## RESPONSE TO SECTION 51 AND SECTION 55 ADVICE

PINS APPLICATION REF: EN010146

Drawing Title  
**DOCUMENT 2.3.1 ONSHORE WORKS PLANS SHEET 1 OF 14**

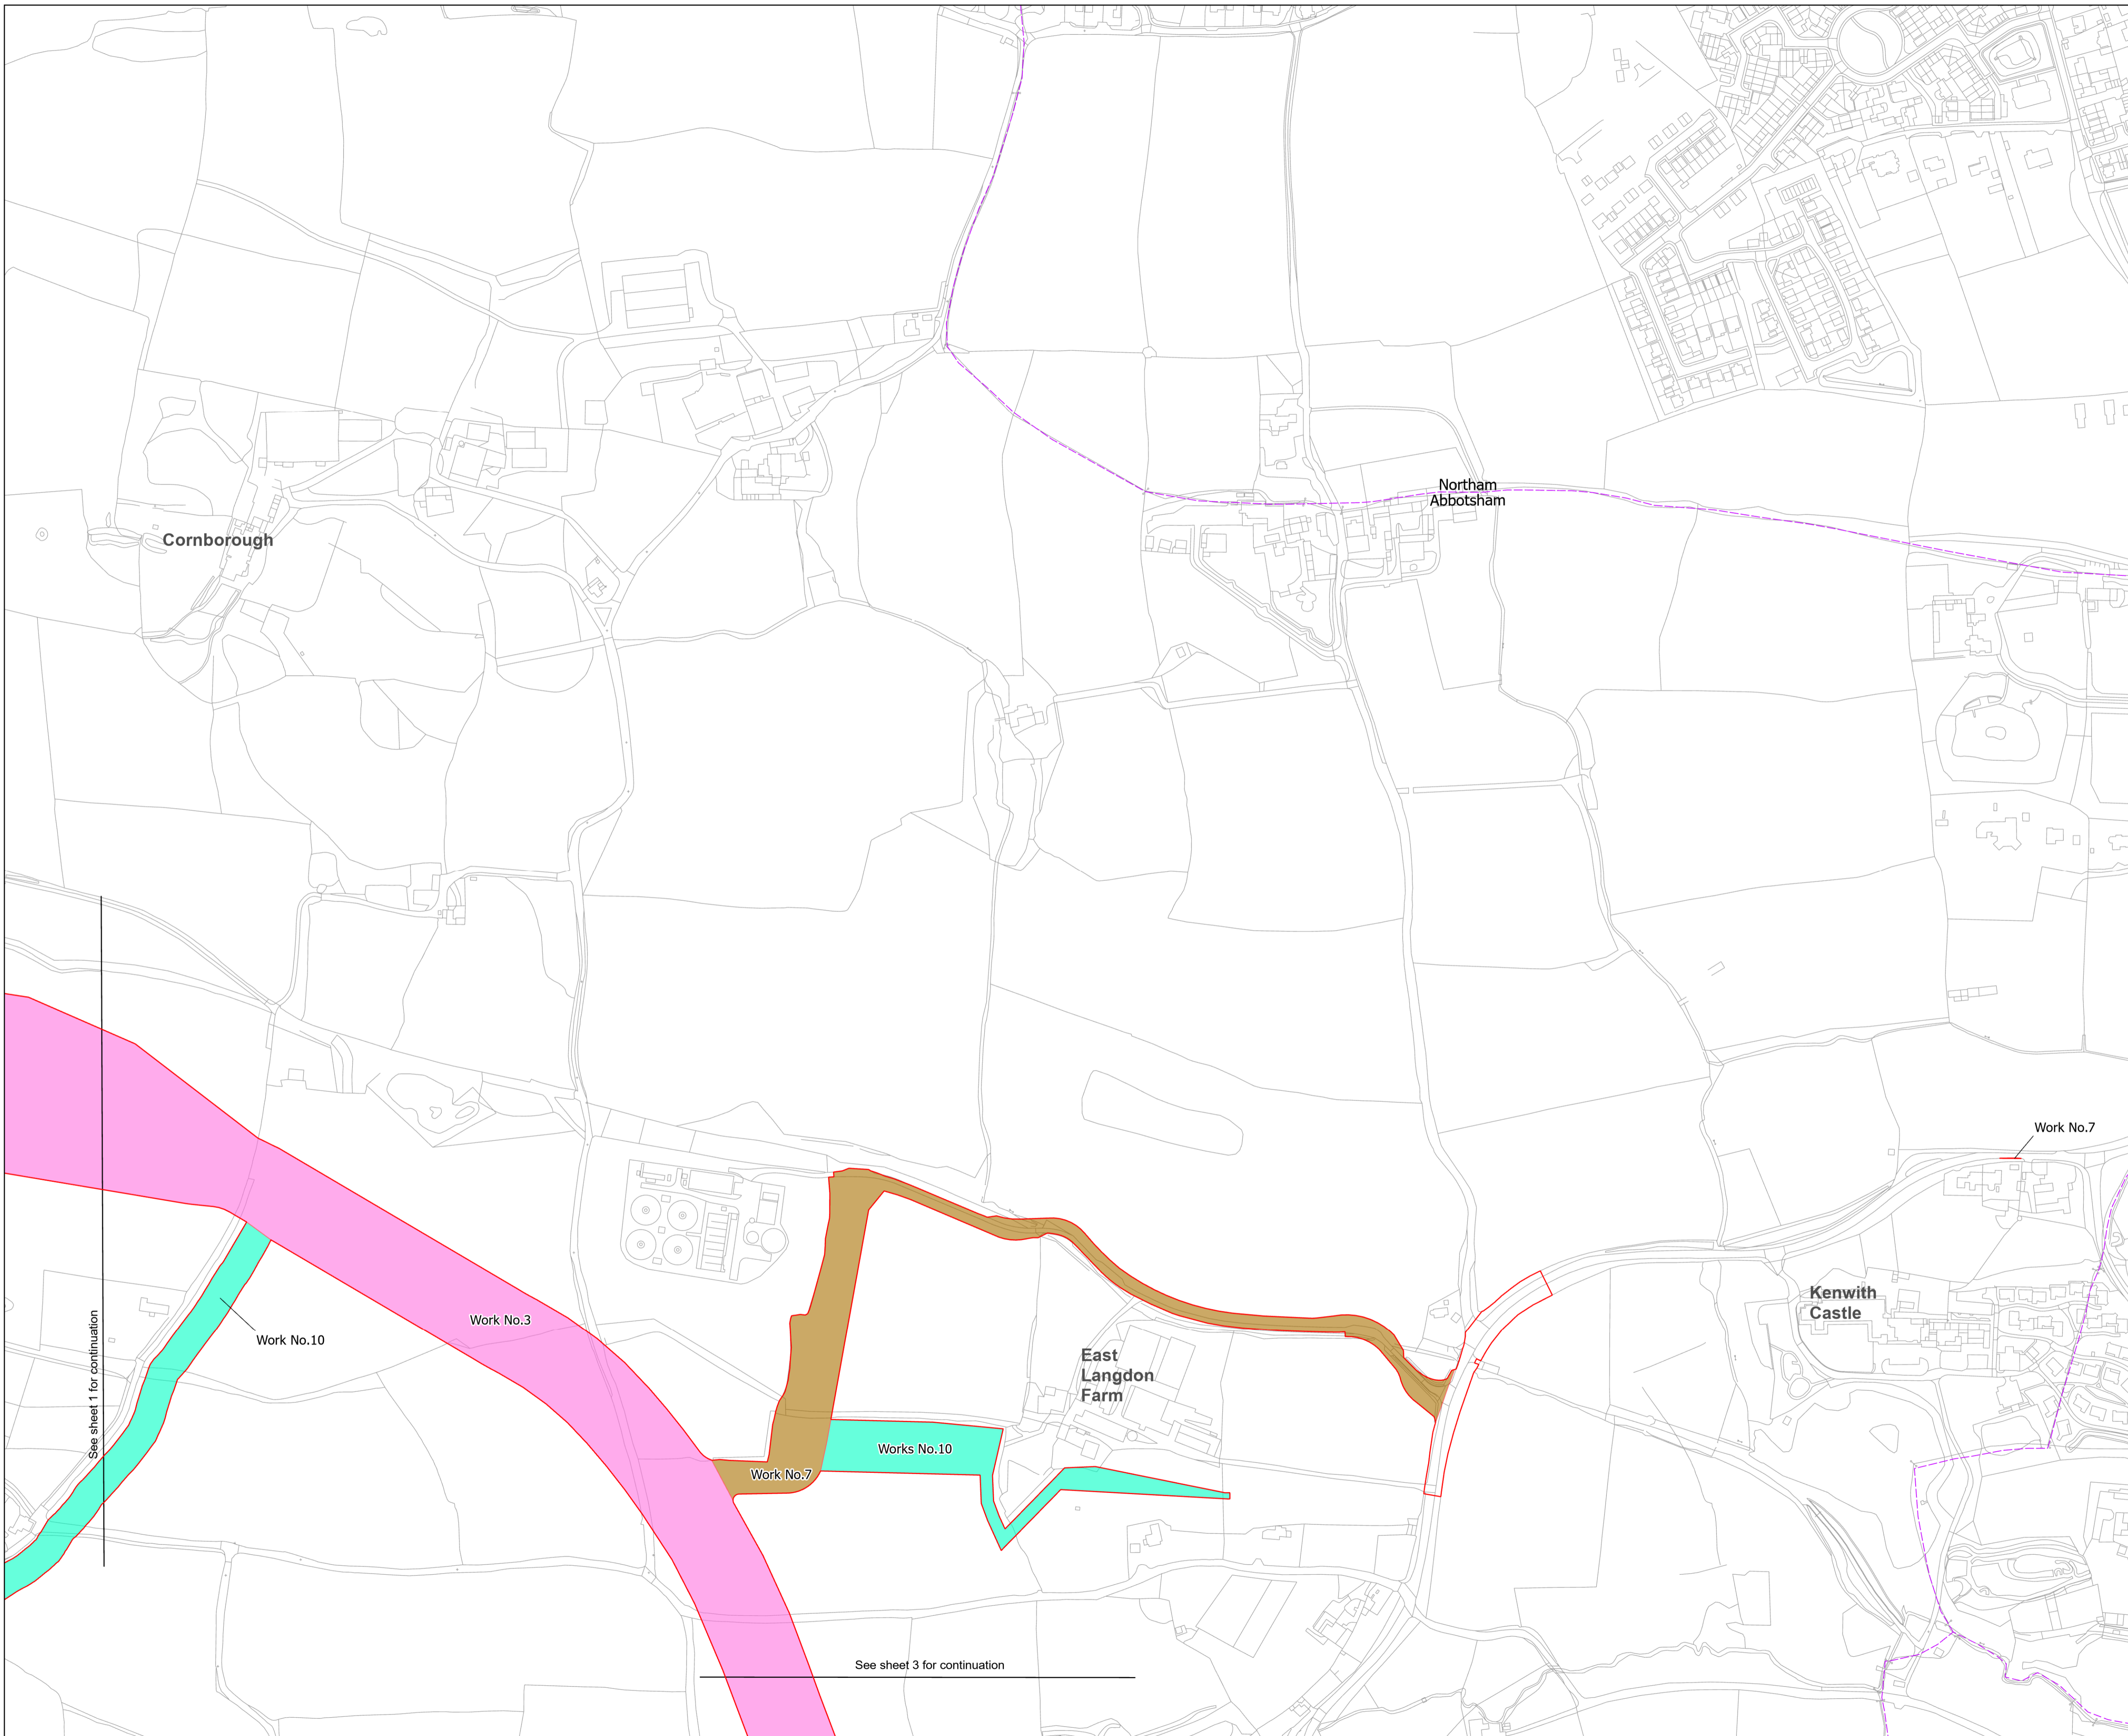
Land Plans [EN010146/APP/2.2]	Blue line (also shown in red) depicted on sheet 1 of 14 appears to show 'Mean High Water Line'; however, this is not listed in the key / legend.	The key on the land plans have been updated to show the Mean High Water Line.
Land Plans [EN010146/APP/2.2]	Sheet 7 Insets: Plots 7-04 and 7-08 are labelled correctly in the main plan but misnumbered in insets 7a, 7c and 7d.	The land plans have been updated accordingly.
